Date: 20 November 2023
Our Ref: 23/00963/FULHH
Please ask for: Simon Lems

Invalid Application

Proposal: Single storey rear extension and new front porch (following part demolition of existing conservatory and demolition of existing front porch)
Location: 17 Chatsworth Court Heath Charnock Chorley PR6 9SA
Reference: 23/00963/FULHH

Location Plan

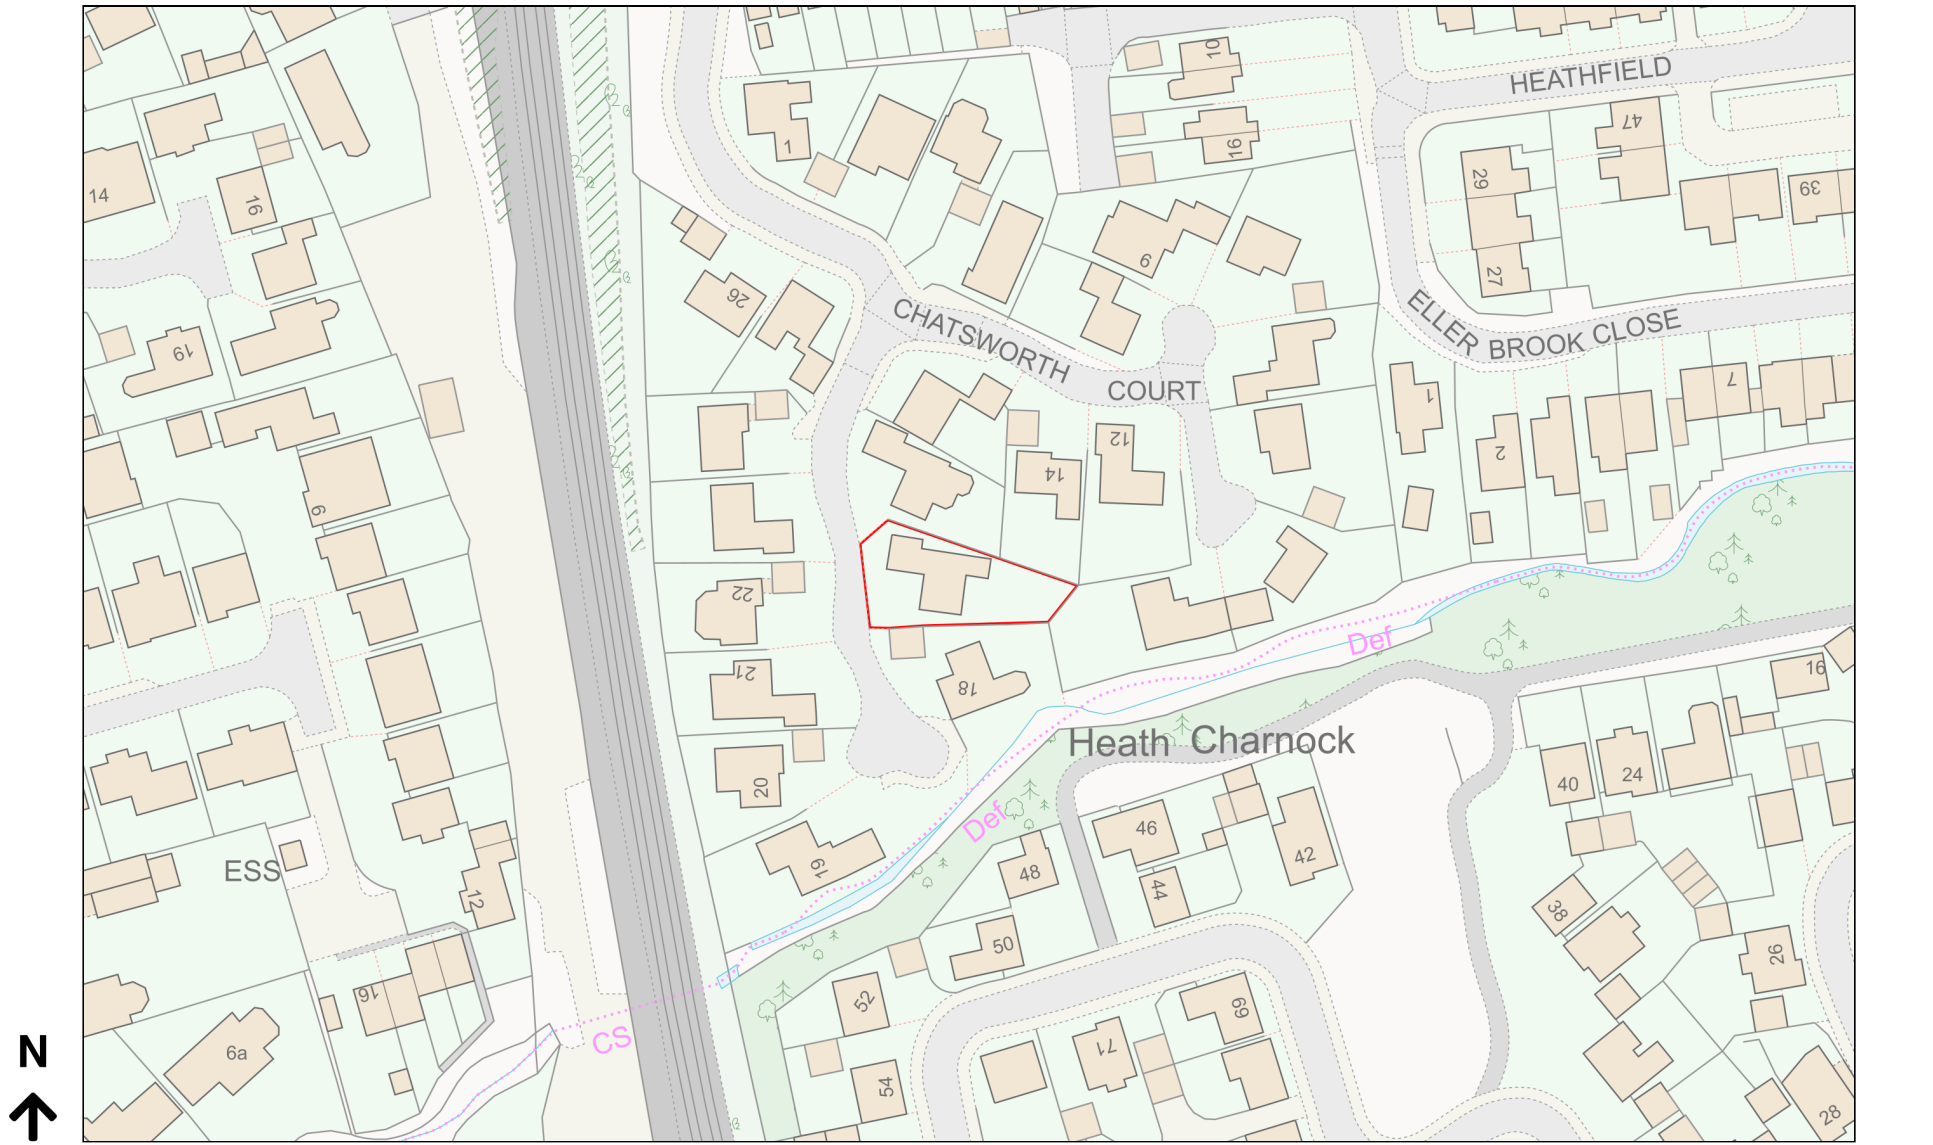
- 1. The location plan is incorrect.**

Please remove the red outline that is surrounding the property, only the red outline around the boundary is needed.
